PENRITH NEPEAN HOSPITAL REVIEW OF SUBMISSIONS AND PREFERRED PROJECT REPORT

Prepared for NSW Health Infrastructure
18 December 2009

Rev 11 - PLANNING REVISIONS - 01-12-09

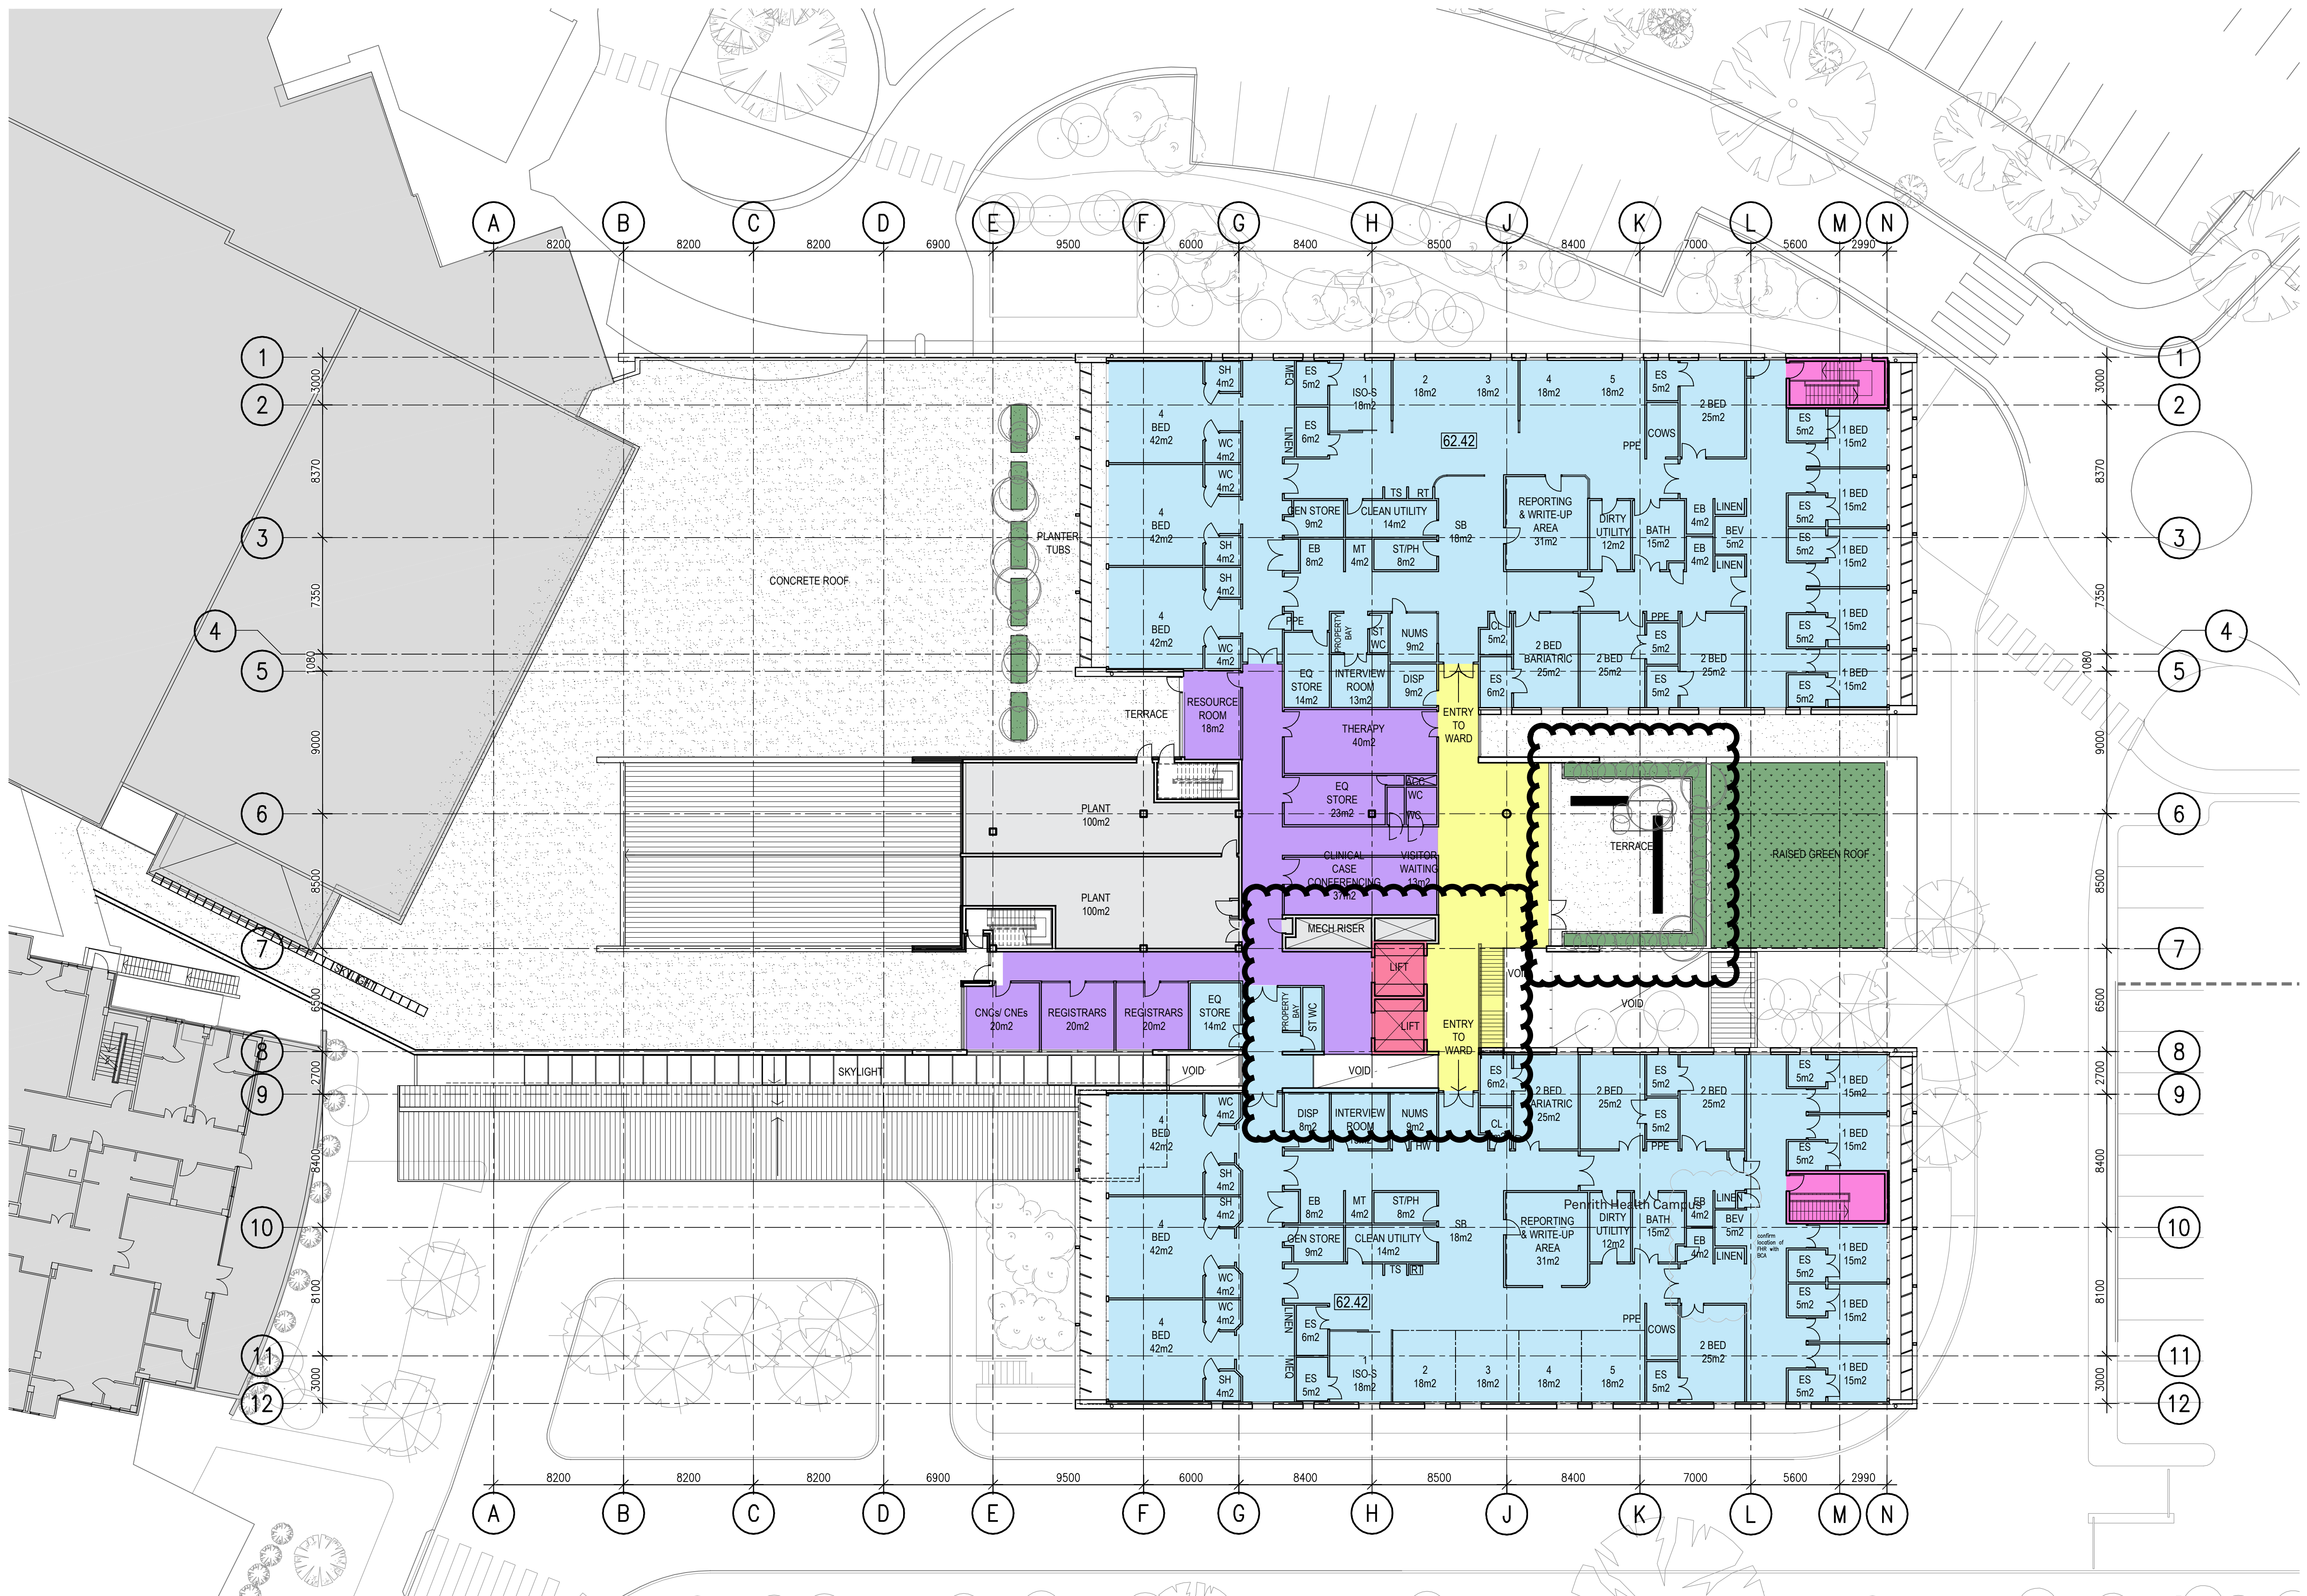
3.3_Modifications to East Block

Following submission of the EA, additional design detail work has been undertaken. This has resulted in a number of minor changes to the layout of the proposed East Block building. A set of plans clearly identifying the changes are provided in Appendix B to this report. A full set of updated plans for the entire proposed development are provided in Appendix C.

Proposed Change	Reason / Comments
Internal layout rearranged on Level 2. Addition of approximately 63sqm of floor space at the north-west corner of the building to accommodate new layout.	The layout change has been made in order to improve operational efficiencies through closer integration of the existing operating theatre suite.
Minor layout change of lift and stair space on Level 3.	Layout altered to improve operational efficiency through greater separation of staff, inpatient and visitor flows and improved wayfinding.
The terrace area on Level 3 has been expanded and access corridor widened. The adjacent green roof area has been reduced.	The terrace area has been expanded to allow use as a patient therapy area to assist recovery after surgery.

The open plant area on Level 4 has been relocated (still located centrally within the roof area).	Improved arrangement for ventilation of cooling towers to provide for greater energy efficiency. Please note that the cooling tower is not visible above the roof line as it is contained within the parapet and screened to the west side.
A fire exit has been added to the corridor linking East Block to North Block (Level 2), near to the North Block entrance.	Fire exit added to comply with Building Code of Australia requirements.

The majority of these changes are internal only. The only changes which will be visible are the infill of the north-west corner of the building and the additional fire exit added to the East Block to North Block corridor, but these changes are relatively minor and do not substantially alter the building footprint or form.
